Goulburn Mulwaree Council
Locked Bag 22
Goulburn NSW 2580

Subject: Marulan Solar Farm (SSD-13137914)

A review of the Environmental Impact Statement prepared by Premise Australia has been undertaken in relation to the above proposal and a report was considered at the 18 October 2022 Council Meeting. Accordingly, Council provides the following as its submission.

MUNRO ROAD INTERSECTION
NTS

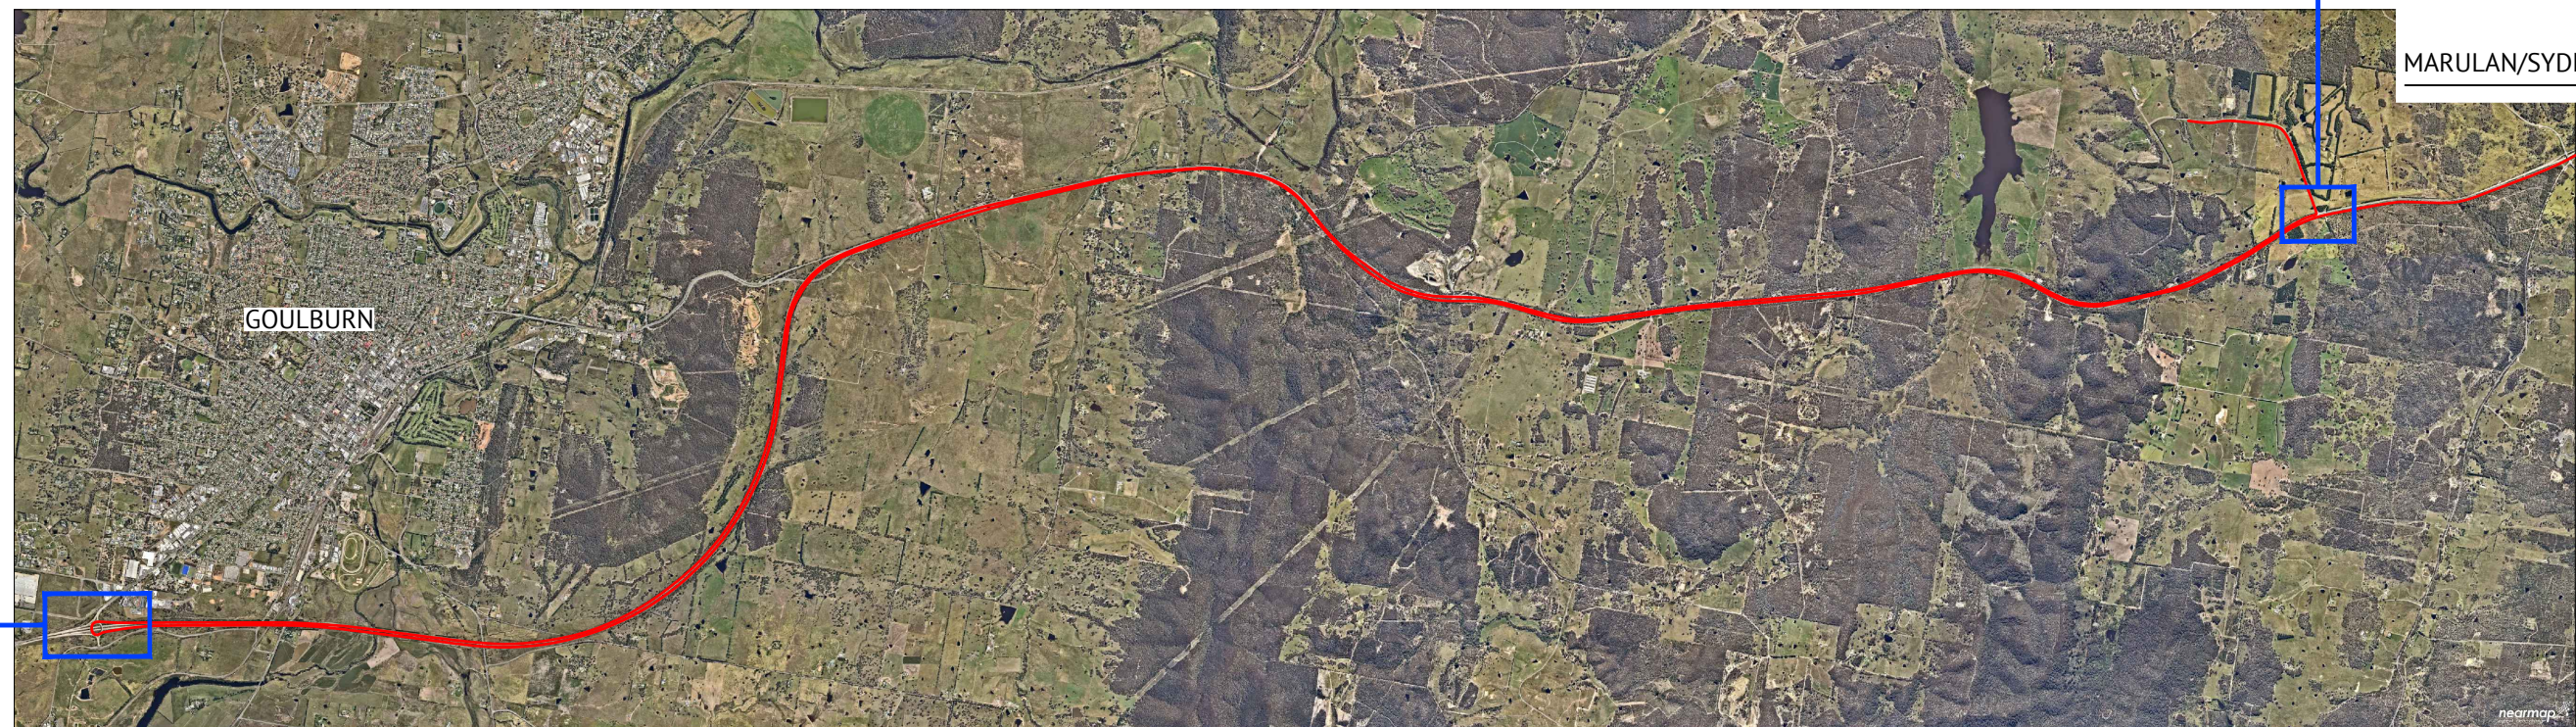
The intersection of Munro and M31 (Hume Highway) is substandard and cannot safely cater for the traffic generated by the development. While this is mainly a TfNSW issue to manage, Goulburn Mulwaree Council would like to ensure that nearby residents are not adversely affected. This would include ensuring residents can still turn right safely to go to Goulburn from Munro Road and that any changes to the intersection are designed to ensure that the driveways 75m east are still safe with full functionality.
